7 July 2020

RE: SSD 6687 UUNGULA WIND FARM – EIS SUBMISSION

Thank you for providing Mid-Western Regional Council (Council) with the opportunity to provide input into the proposed Uungula Wind Farm. Council has reviewed the Environmental Impact Statement (EIS) and would like to provide the following feedback for consideration.

PROJECT	UUNGULA WIND FARM
DRAWING TITLE	TWELVE MILE ROAD LOCALITY PLAN, TITLE SHEET & DRAWING INDEX

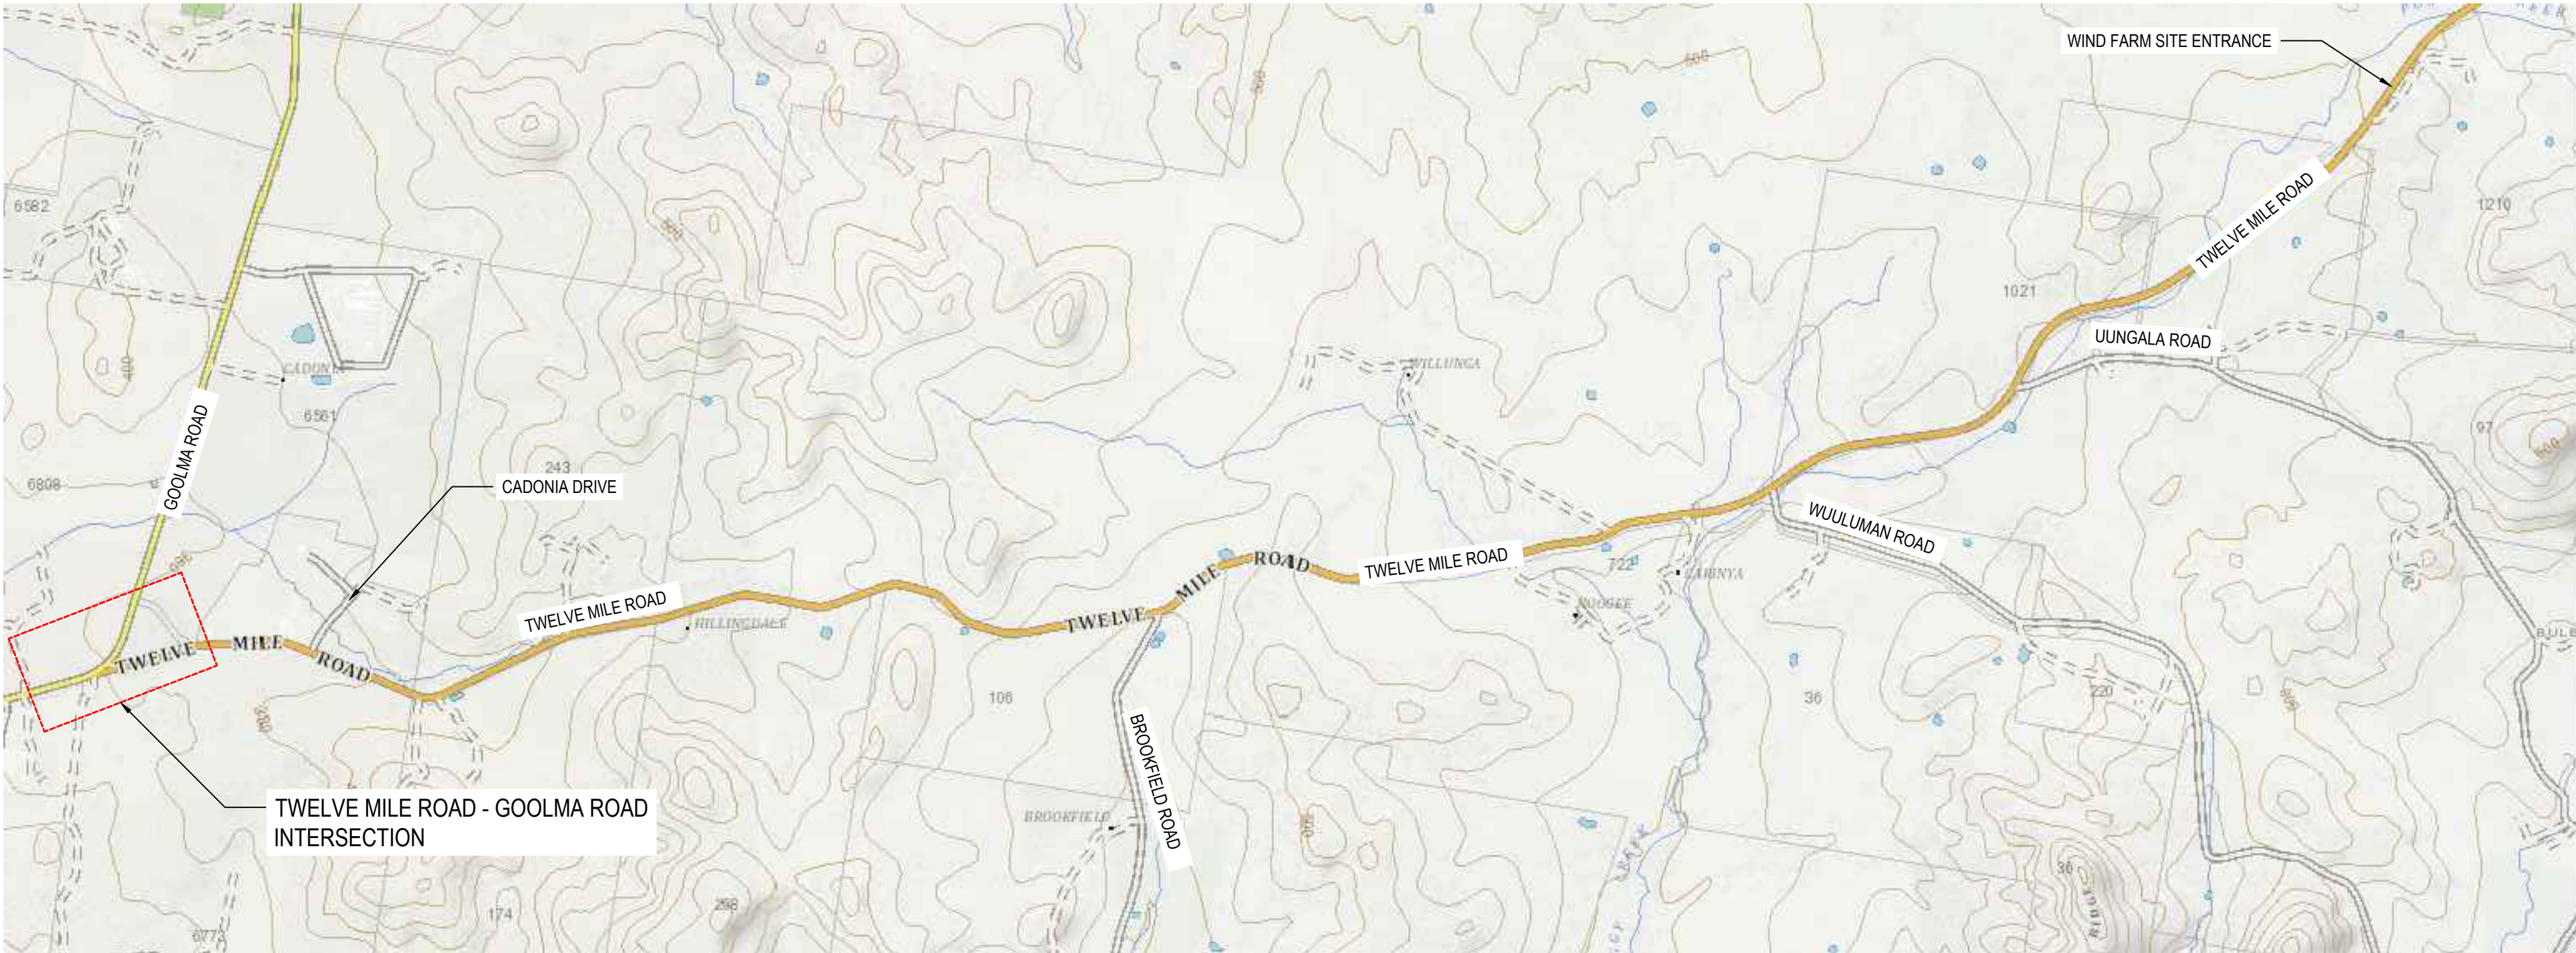
Council would like to raise concerns in relation to the use of the Eastern End of Twelve Mile Road. In the Transport Assessment, the proponent has sought an exception to not prohibit heavy and light vehicles to use this section of Twelve Mile Road. Council does not support this exception.

Council is aware that there will be some construction workers and/or contractors travelling from the east to deliver materials (eg. water, cement, sand, gravel, general materials) during construction. As the Eastern End of Twelve Mile Road may be seen as a short cut to the project site, this is likely to cause significant issues for the safety and amenity of local residents.

The Eastern End of Twelve Mile Road is not constructed to an adequate standard suitable for any construction vehicles. Therefore, unless the applicant is prepared to upgrade this section of the road to the same standard as what is proposed for the Western End of Twelve Mile Road, Council recommends a condition be imposed which prohibits the use of the Eastern End of Twelve Mile Road by any vehicle associated with this project. The condition should state that all project related traffic is required to access the project site using the Western End of Twelve Mile Road.
